**Engineering Review**

**Windermere 2022 Zone Change  
Traffic Impact Study  
(LSC #S224090)  
April 27, 2022**

# Windermere Zone Change Traffic Impact Study

Figure 2

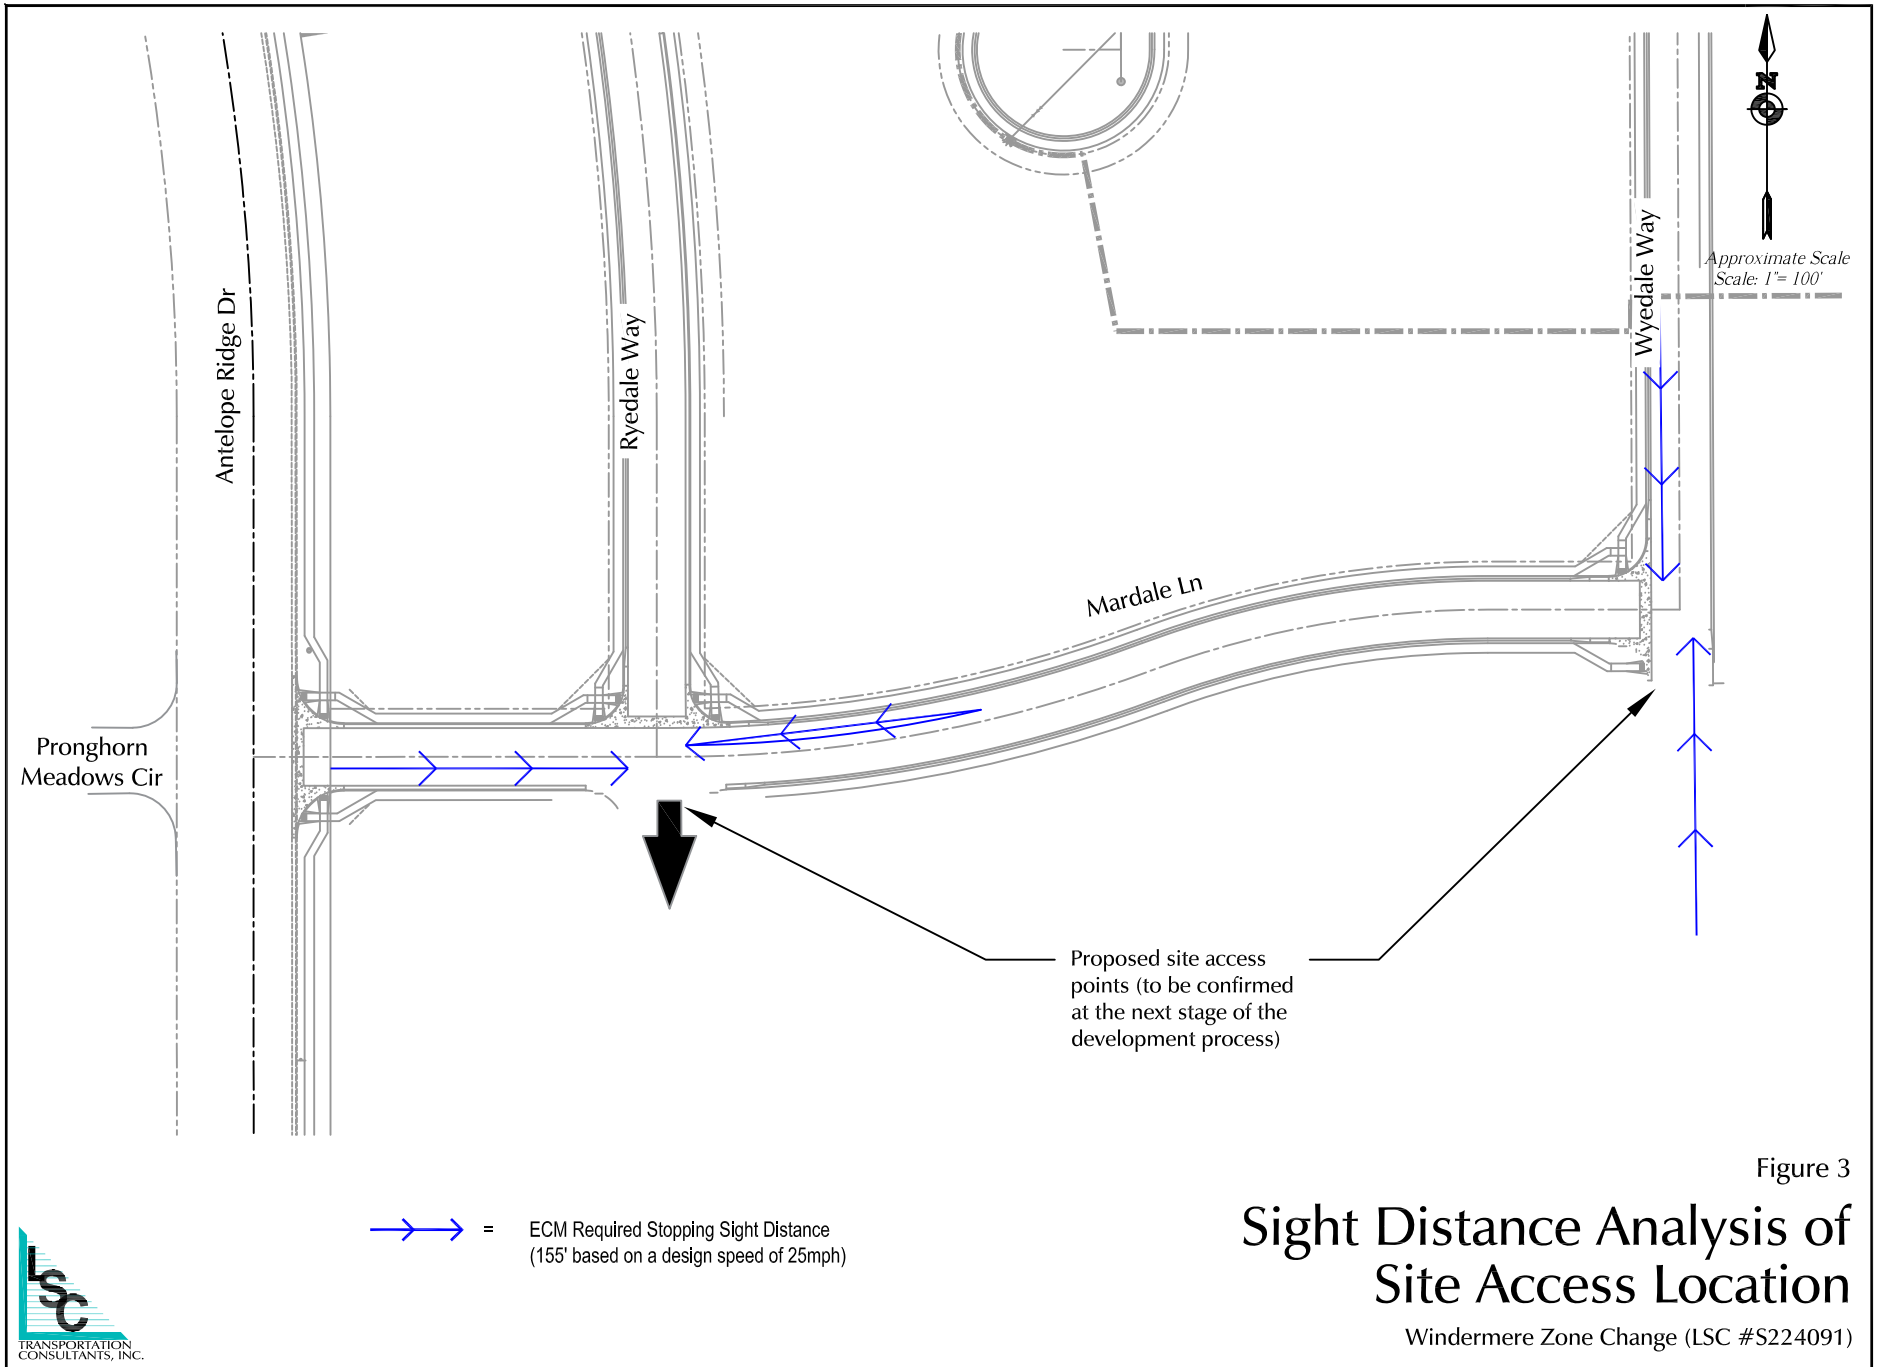
Address access to  
this parcel from  
Mardale Lane

Address this tract's access also.
